**APPLICATION NO:** 24/00018/FUL/ADDINF

**DESCRIPTION:** Proposed construction of two storey rear extension, garage conversion and permeable paving at the rear garden.

**LOCATION:** 53A Fernbank Road Ascot Berkshire

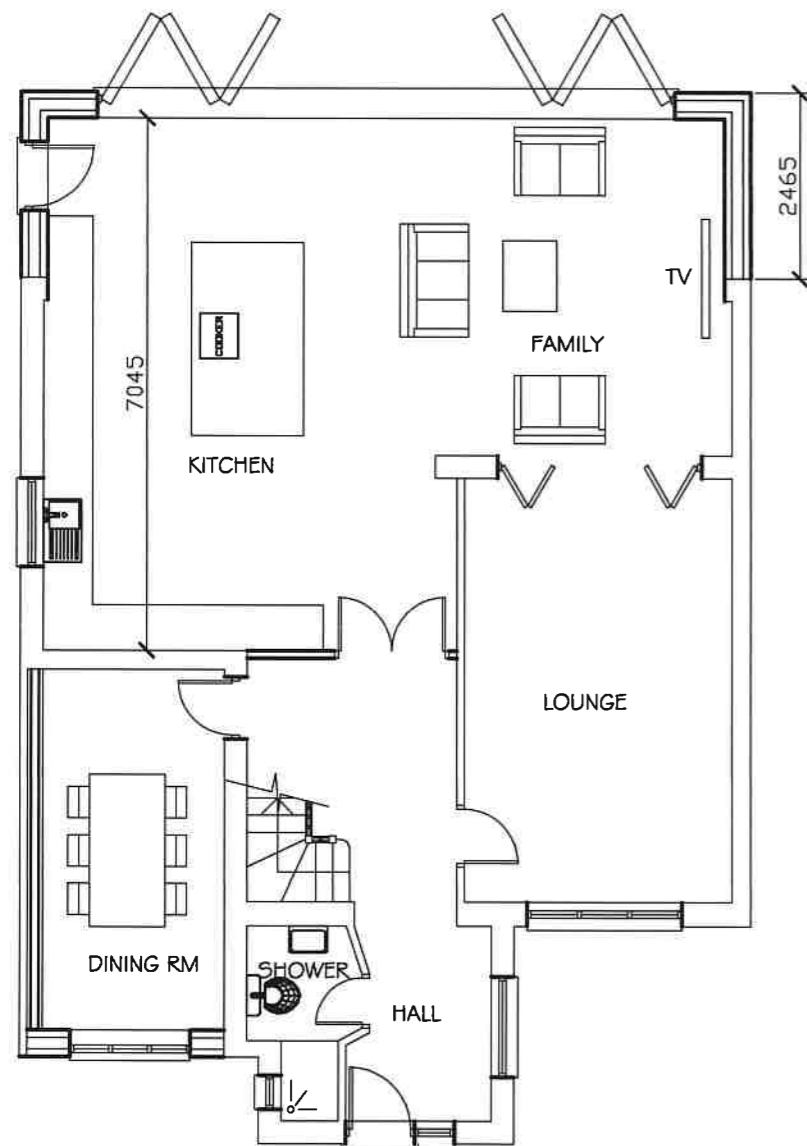
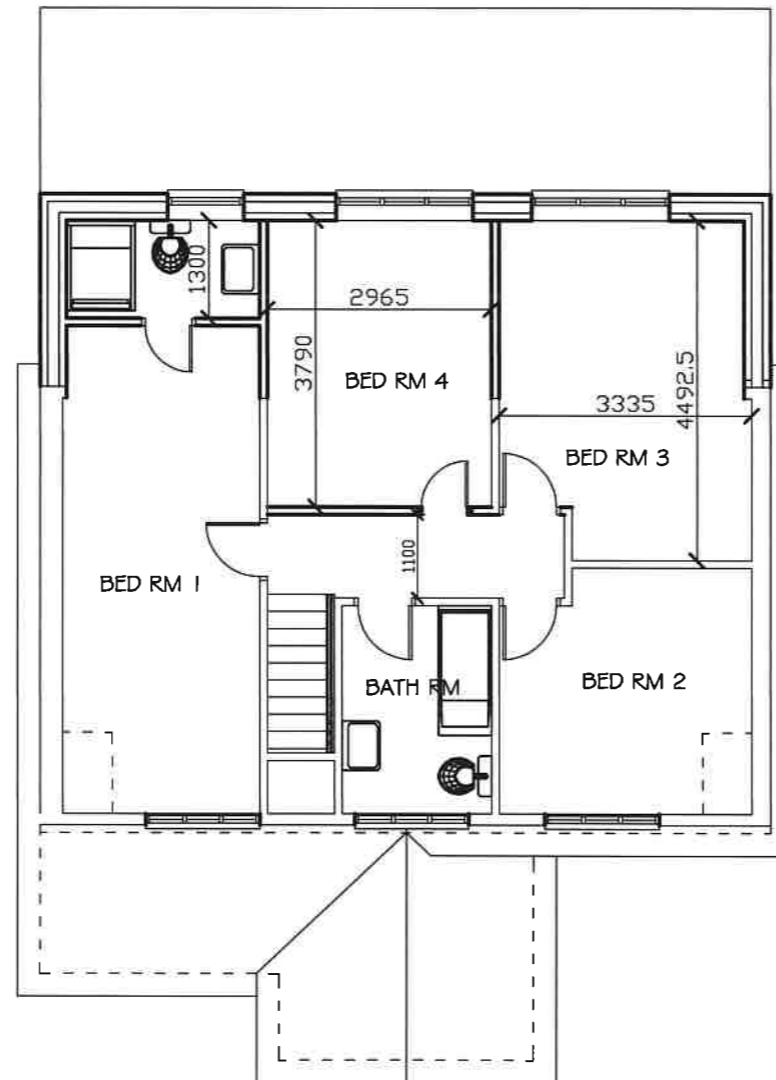
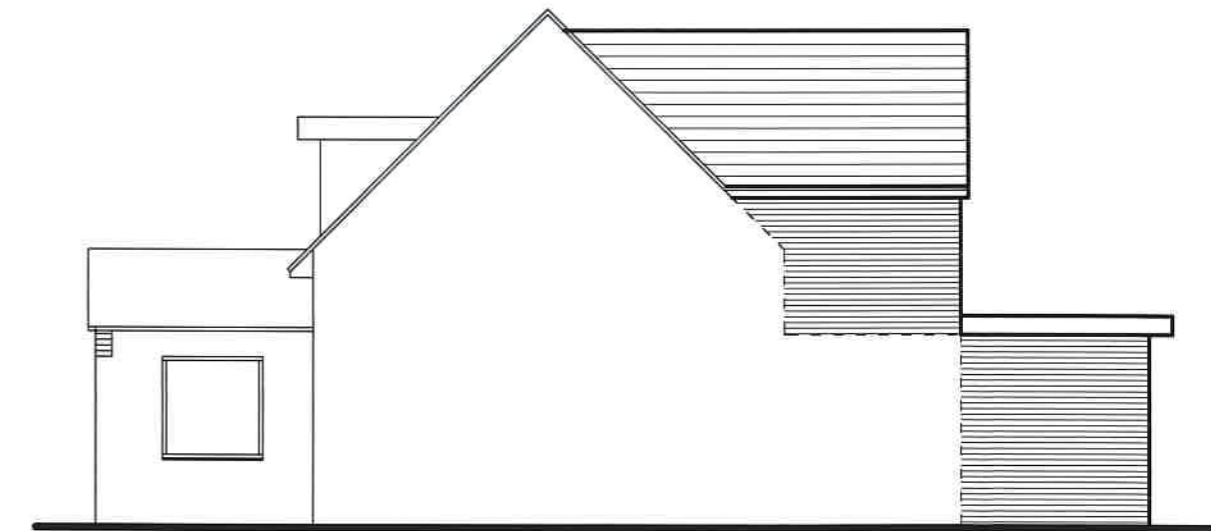
- 1 There is a window shown on the proposed ground floor plan in missing on the right side elevation.
- 2 Please provide a parking plan.
